**RE: REQUEST FOR ADDITIONAL INFORMATION – 2 OCTOBER 2020
DARLINGTON PUBLIC SCHOOL REDEVELOPMENT (SSD-9914)**

This letter has been prepared by Ethos Urban on behalf of School Infrastructure NSW (SINSW), the proponent for redevelopment of Darlington Public School under SSD-9914, in response to the request for additional information made by the NSW Department of Planning, Industry and Environment (DPIE) on 2 October 2020. The response relates to the following issues that were raised by DPIE:

01 SECTION  
1:500

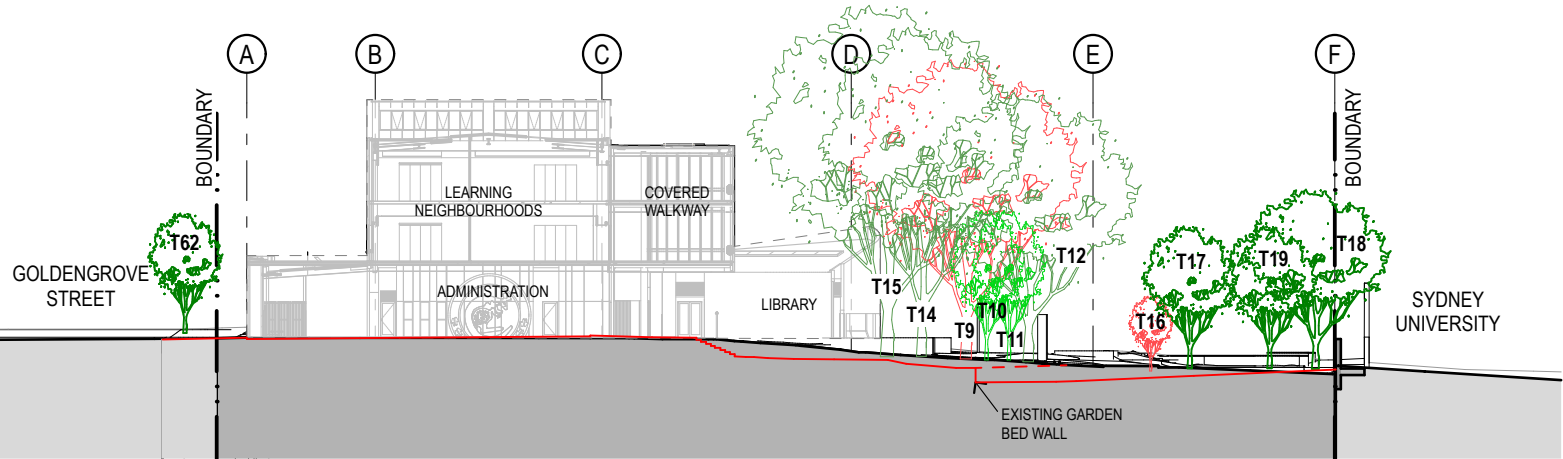
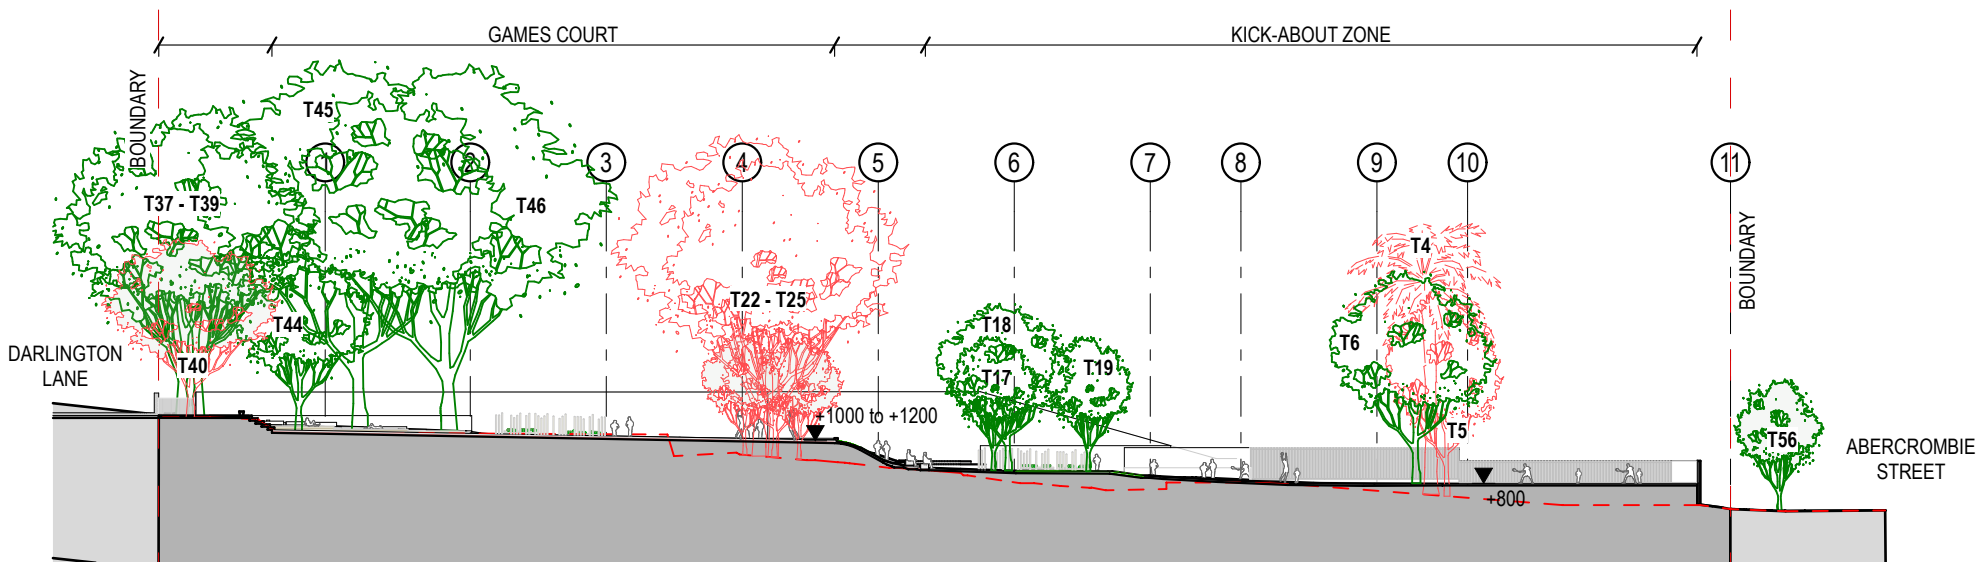
DPIE also requested that section drawings be provided to assist with understanding the impact of level changes to existing trees. These section drawings are provided at **Attachment G**.

DPIE Comment	Response
<i>Trees 10 & 11 (River she oaks) – whether these could be retained along with tree 12 (currently proposed for retention), given their location, significance, health etc.</i>	Tree 10 and Tree 11 are located on the edge of a brick retaining wall and pavement which are to be removed in the proposed design. The team has concern over the stability of the trees once the wall is removed. Tree 10 and Tree 11 could potentially be retained they can be accommodated in the garden. As such, these trees are proposed to be retained if possible, subject to further investigation.
<i>Boardwalk – whether non-slip materials are available which could cover it (in case leaves / needles are considered a slip hazard)</i>	The ramp has been designed to be compliant with a slip rating of R11. The primary concern is that an additional slip rating would not provide much assistance since the needles will form a layer over the ramp's surface and continue to create a slip hazard.

<i>Trees 1 & 2 – whether changes to the pedestrian entrance might allow for retention.</i>	These trees are proposed to be removed due to changes to existing levels to meet overland flow requirements due to existing flooding on site and the provision of a new accessible pedestrian entry and vehicular entry including emergency vehicle access. To retain these paperbark trees, a new raised planter would be required due to the change in level (approx. 500+mm). In accordance with the Arborist requirements, the size of the planter is to align with the tree's TPZ. The combined TPZ will protrude into the new footpath zone and is the full width of the entry way (refer diagram).

<p><i>Trees 7 & 8 – we didn’t quite get to these, but I note they were marked for discussion on your presentation and they are located in a proposed informal garden area. It would be good to understand if the possibility exists to retain these also</i></p>	<p>Changes to levels to create new accessible entry path, as well as grading to deliver the overall overland flowpath, result in 2m difference in height between the adjacent COLA and the existing soil level for Tree 7 and Tree 8.</p> <p>If Trees 7 and 8 were to be retained, a retaining wall to retain 2m of soil would be required and the trees would be approximately 2m below the COLA level and 1m below the eastern foot path level.</p> <p>Retention is not recommended due to the extreme level differences.</p>
